THE THANET EXTENSION OFFSHORE WIND FARM ORDER

Responses to First Written Questions

Submitted on behalf of the Port of London Authority and Estuary Services Limited

Unique Reference Number	EN010084
Rule No.	8(1)(b)
Document Ref.	PLA 6 / ESL 6
Author	Winckworth Sherwood LLP
Date	15 January 2019

Figure 3: PLA Simulator extent (ESL Pilot Launch tracks also shown - demonstrating area of activity for North East Spit Station).

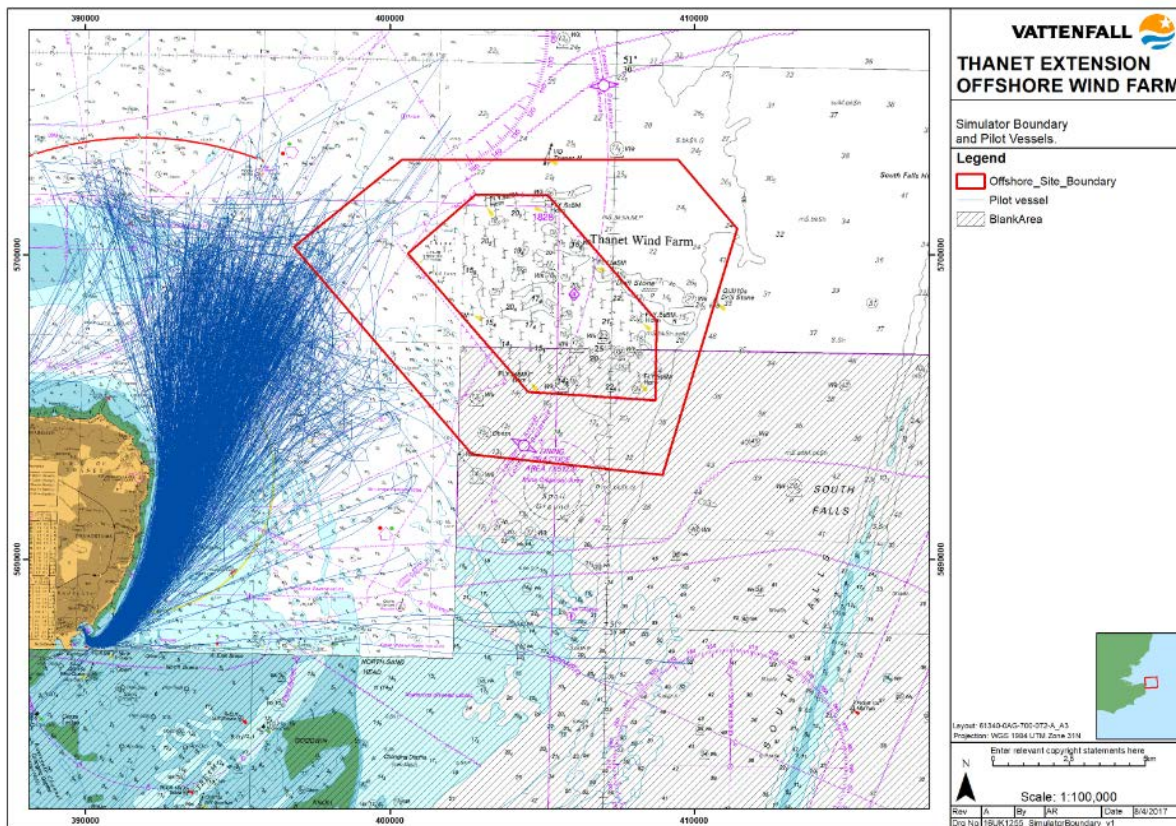
<p>d) to what extent the exercise represented “real world” conditions in respect to local knowledge and communications ability in English of the actors in the simulation and their learning gained by performing multiple runs during the simulation?</p>	<p>The extent to which the exercise represented real world conditions was very limited. The simulator presented an unrealistic and sterile version of shipping and landing at the NE Spit pilot station, and favourable conditions to those that are experienced in ‘real world’ scenarios. In particular:</p> <p>i) Communication between pilot launch and all vessels served was good with no language/communication ‘barrier’ tested. There was no provision made for the potential lack of understanding of the cutter’s requirements in the case of any restricted ability to communicate in English.</p> <p>ii) All vessels were ‘manned’ by participants with extensive local knowledge as either a pilot or launch coxswain, which would not be the case in real conditions. The simulations did not fully take into account the lack of local knowledge of a Master bringing his vessel to the NE Spit for the first time.</p> <p>iii) MetOcean Conditions:</p> <ul style="list-style-type: none"> • The extent to which the PLA simulator can re-create true environmental conditions is limited. It does not represent true darkness and does not give a true impression of the weather that may be being experienced. The simulation runs undertaken did not represent the full range of environmental conditions, e.g. wind strength and direction in which the pilot cutters are able to operate, using a maximum of 25 knots. • It was agreed between the Applicant and ESL that 25 knots could represent ‘challenging operational conditions’, particularly from the direction of north west through to east but ESL expressed concern that the simulator did not realistically represent 25 knots. In ESL’s experience winds of 25 knots from the

<p>northwest through to east would generate a minimum wave height of 1.5m (and above), which would be further influenced and increased by tidal conditions (height, strength and direction), historical weather conditions (wind history in hours and direction) and charted depth of water. These effects were not apparent during the simulation. Height of tide during the simulation was represented by two states of tide (being either high water or low water (+3)) which is not an exhaustive representation of the scope of tidal heights, and in particular does not represent low water conditions. Vessels of a deeper draft (approx 10m) can be served closer to low water, this would be factored into the launch programme typically after consultation with the coxswain/DPC and pilot. A larger (10m draft) vessel being served closer to low water would have to remain to the east of the boarding ground, at least 1nm depending on other traffic.</p> <ul style="list-style-type: none"> • Visibility issues, although factored in, cannot be adequately accounted for in the simulation. Night conditions under the simulation are closer to a representation of summer/dusk conditions. Pilot launches are heavily reliant upon radar in reduced visibility but the tug simulator did not have a radar which, in real world conditions, would have been essential for 5 of the simulated runs. • Met-ocean conditions in the simulator did not reflect the reality of launch/ship interaction. <p>iv) Pilot Launch:</p> <ul style="list-style-type: none"> • The simulator does not have a model of a pilot cutter so the pilot cutter was substituted with a tug, which reacts very differently. This raised obvious issues in terms of a 'true' launch representation. The tug's

<p>handling alongside the ship and interaction with MetOcean conditions were very limited. The tug simulator, as explained in iii) above (MetOcean conditions), was also without a radar facility which is an essential navigational tool used on pilot launches, particularly in reduced visibility; ESL standing orders are that they cannot proceed to sea without a fully operational radar.</p> <p>v) No emergency scenarios were simulated</p> <p>vi) Other craft</p> <ul style="list-style-type: none"> • Overall, representation of leisure/'other' craft was too simplistic, particularly as all traffic outside of pilotage behaved in full compliance with the rules of the road which is not always the case in real world conditions.
		<p>e) to what extent did the exercise incorporate impinging factors such as small vessels without AIS and crossing traffic?</p>	<p>The representation of crossing traffic and small vessels without AIS, such as leisure craft, was overly simplistic. Mostly notably, all traffic outside of pilotage behaved in full compliance with the rules of the road which, as previously stated, does not accurately represent the real world experience.</p> <p>The simulations involved up to four vessels, coming to or from the pilot station, at any one time. A couple of runs included an additional vessel passing through the area, but the simulations did not include the range of small vessels such as recreational vessels and crossing traffic, such as windfarm support vessels, that may be found in the area.</p> <p>Unlike in real world conditions, there was no radar available to</p>

<p>track 'unknown' small craft. Instead their presence was tracked on a 'chart plotter' display, which ESL would not in real world conditions be able to rely upon.</p>
		<p>f) are there any other relevant factors or considerations that should have been taken into account?</p>	<p>Due to the high volume of traffic that can be served at the NE Spit there are often be scheduling issues. Typically these occur when multiple vessels are travelling both inward and outward consistently over a period of several hours. Whilst the boat programme tries to account for this there can often be spontaneous adjustments made to the run programme by the launch coxswain. Unforeseen delays – for example due to deteriorating weather, incorrect ladder preparation, or traffic congestion – means vessels may need to be 'pushed back' to the following run to accommodate other shipping. This 'pushed back' vessel will have to remain in the vicinity of the boarding ground while avoiding conflict with other traffic. During the simulator process every run was individual and isolated with no consideration given to intensive multiple run workload periods.</p> <p>In ESL's view, the 'failure criteria' (1-6) seem unlikely to occur with the types of scenario being tested (section 4.2, Simulation Run Grading of the Bridge Simulation Report). Apart from point 1 (Ship lost control and was unable to manoeuvre safely), which was not factored into any of the simulations, each of the 'failure criteria' points would be very hard to meet when looking at the limitations of the simulator (limited number of vessels being simulated at any one time for example) combined with the experience of the participants in the study. All non-pilotage vessels in the study were operated by a pilot or pilots and fully adhered to the rules of the road, which was combined with good communication and all participants being aware of the structure of each run. The conditions were therefore favourable to what would be</p>
